## SPR EA1N and EA2 PROJECTS

### DEADLINE 11 – COMMENTS ON THE DRAWINGS IN THE DESIGN AND LAYOUT OF THE SUBSTATIONS SUBMISSION IN RESPONSE TO R17QE ISSUED ON 13 MAY 2021

Interested Party: SASES      PINS Refs: 20024106 & 20024110

Date: 7 June 2021

**Figure 29.17 Update Viewpoint 5 Public
Rights of Way, near Moor Farm**

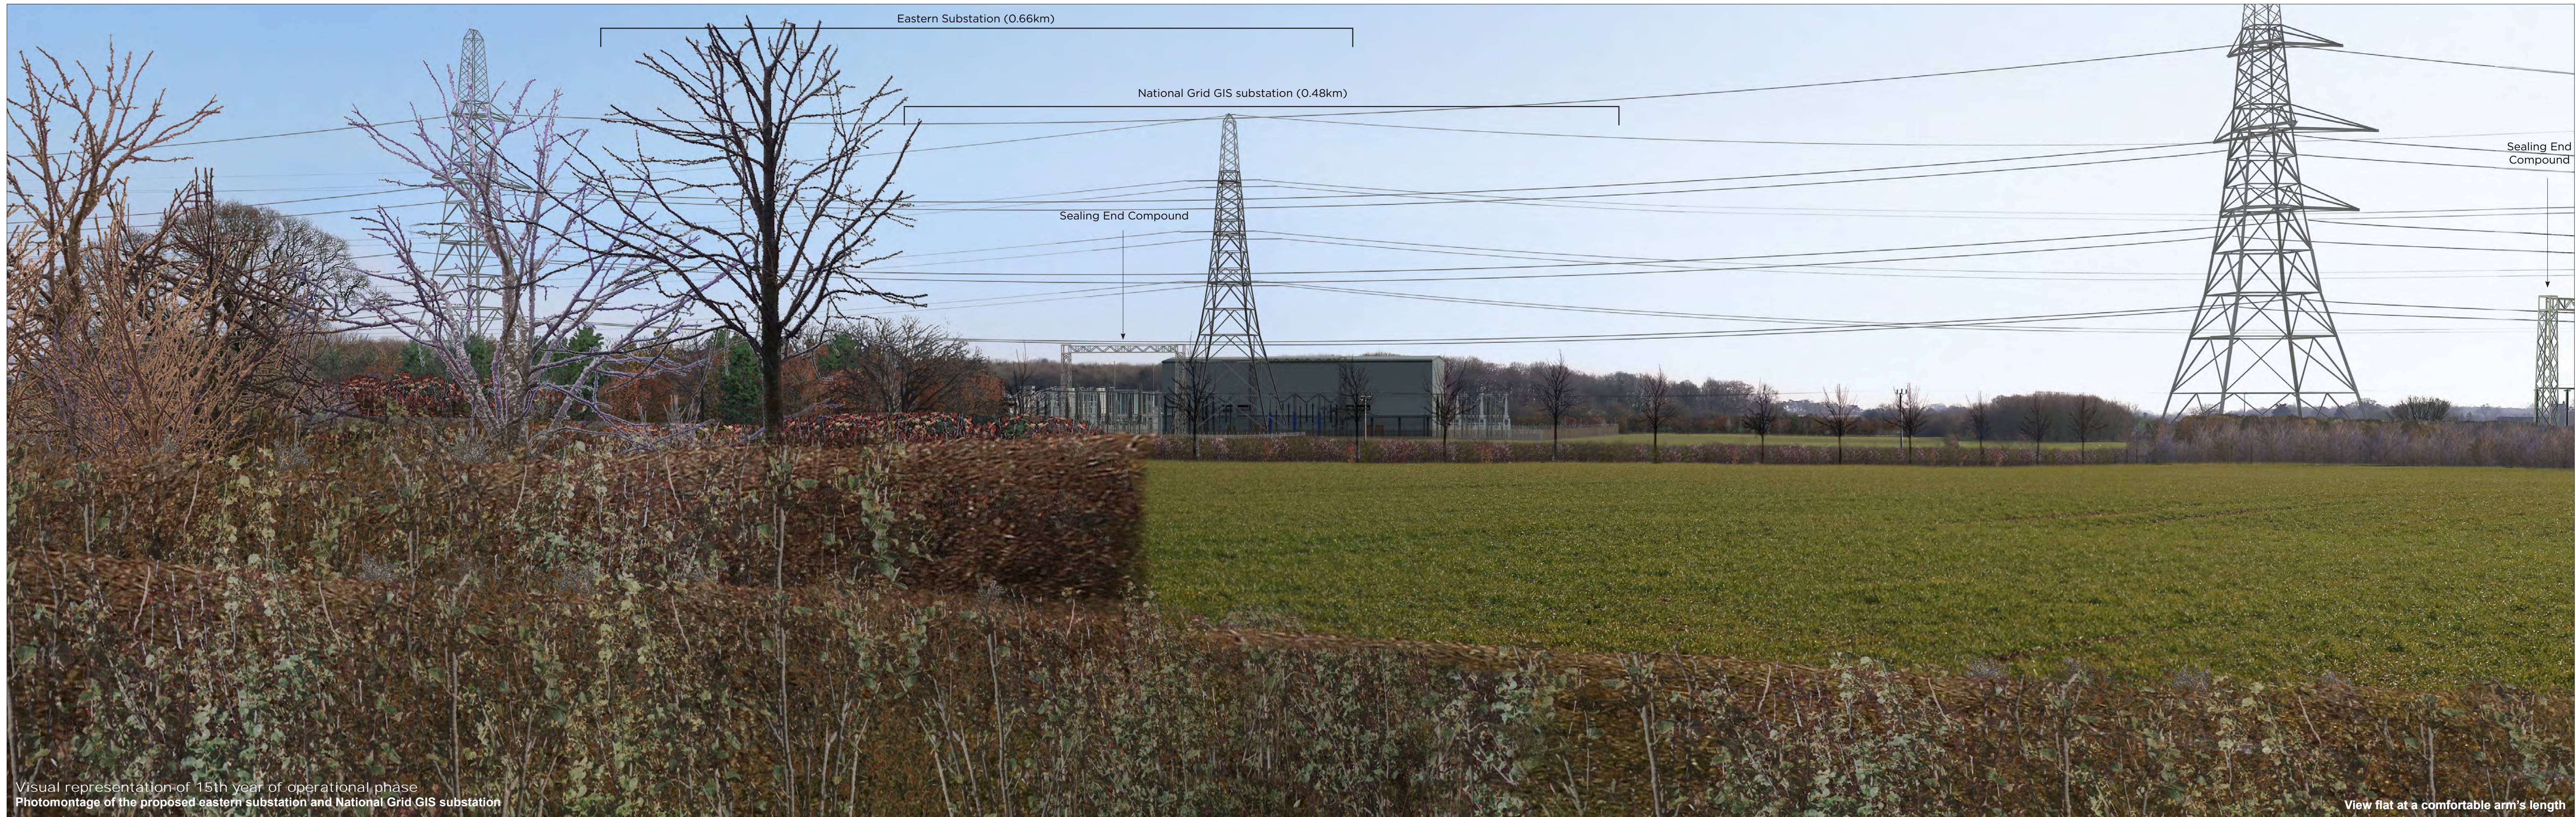
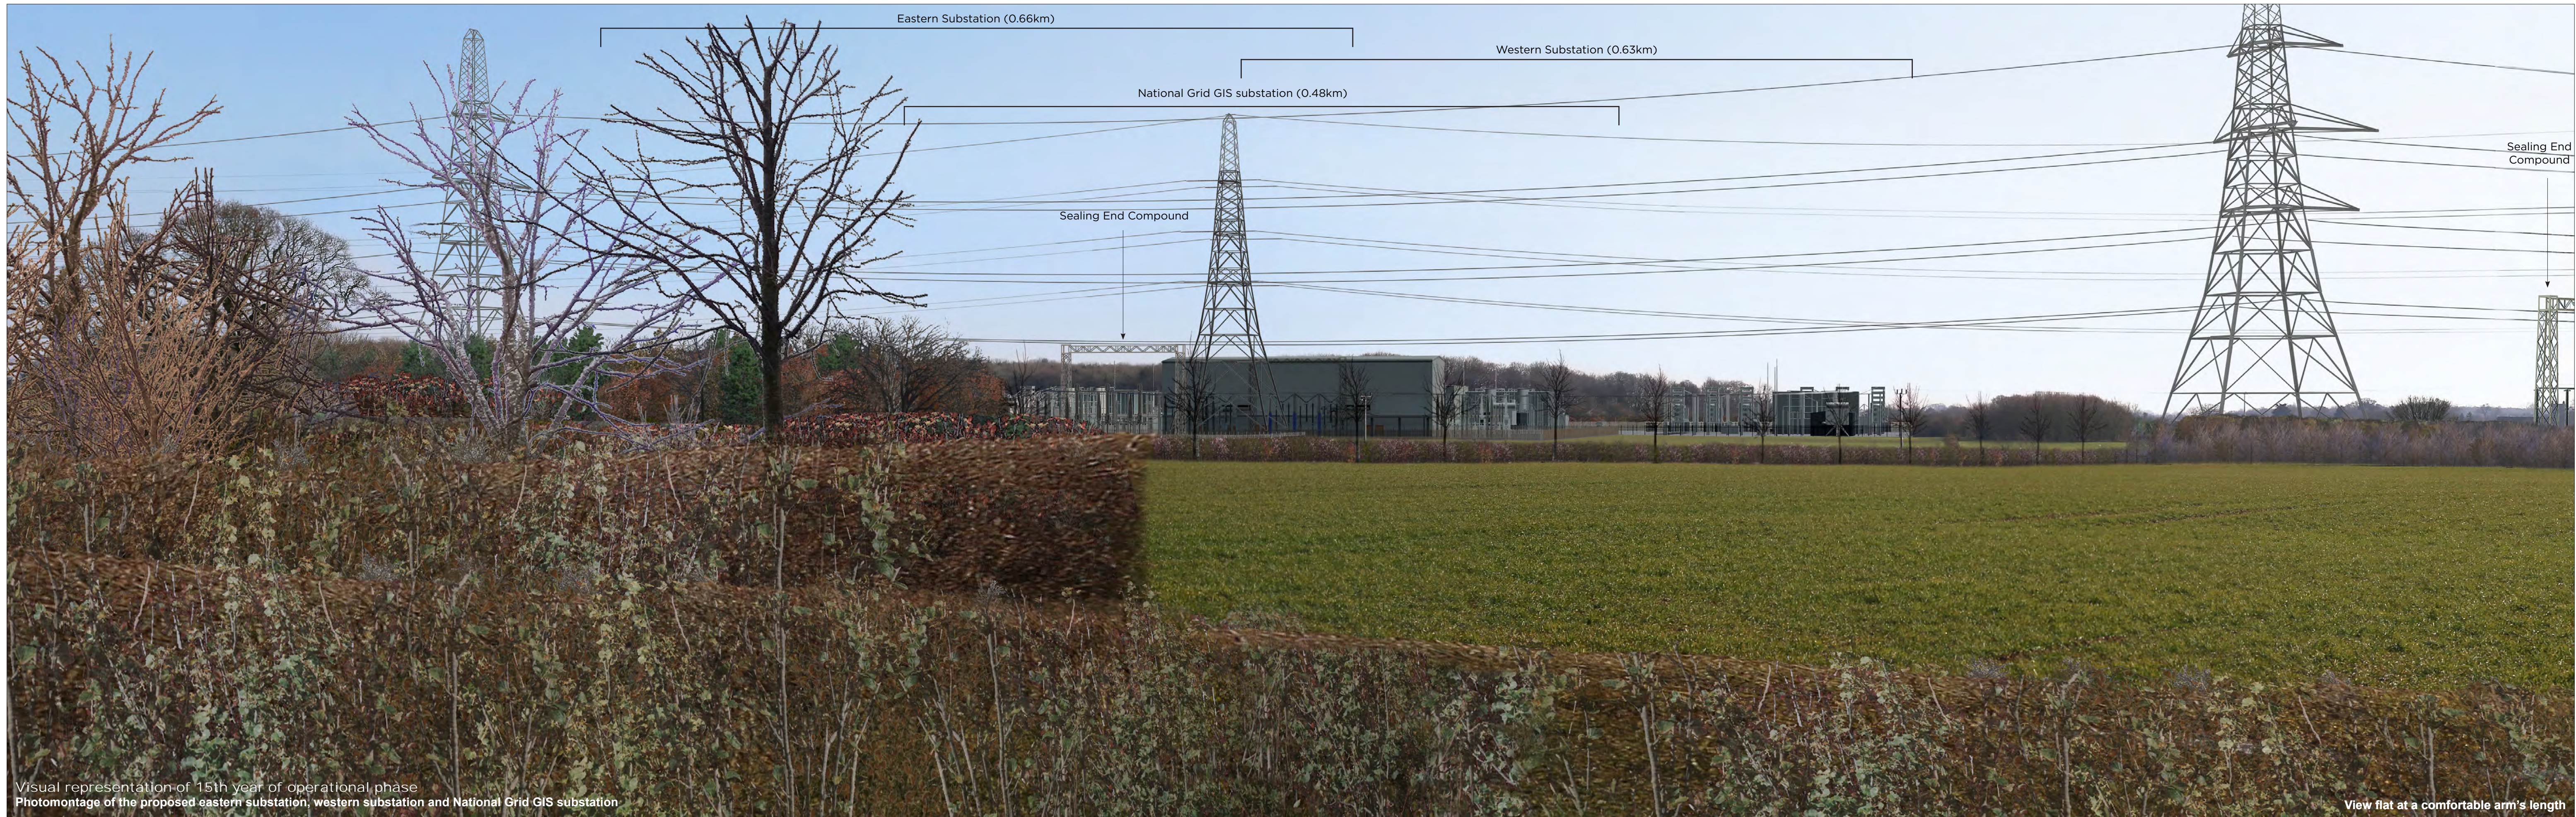
Substation Photomontages: Figure 29.17 Update Viewpoint 5 Public Rights of Way, near Moor Farm (REP8-057)

2. This includes a photomontage of the proposed western substation and National Grid GIS substation which shows the westernmost cable sealing end with two gantries.

3. There are a number of errors.
  - a) The OHLs end on the right hand pylon, when of course they continue on
  - b) The quad core OHLs are shown as thin cables

- c) The cables are inaccurately positioned on the tension pylon, they should be much higher
  - d) None of the OHL insulators are shown (they will be especially prominent on the tension pylon by the western most sealing end)

- e) The many cables and insulators and hardware from the sealing ends and gantries up to the OHL are not shown.
4. Photographs of complete sealing ends are shown on page 111 of Chapter 6 of the Environmental Statement, Project Description  
<https://infrastructure.planninginspectorate.gov.uk/wp-content/uploads/projects/EN010077/EN010077-001060-6.1.6%20EA1N%20Environmental%20Statement%20Chapter%2006%20Project%20Description.pdf>

5. These show how much more visible the typical final solution is. Further the westernmost cable sealing end has two gantries and two sets of conductors from the gantries up to the OHLs compared to the single one shown in these photographs.

6. Further it is not clear whether these photomontages reflect the larger footprint and more robust design of the four new pylon towers (including the one additional pylon tower) which are shown reflected in the drawings attached to the Applicants' Design and Layout of the Substations submission referred to below.
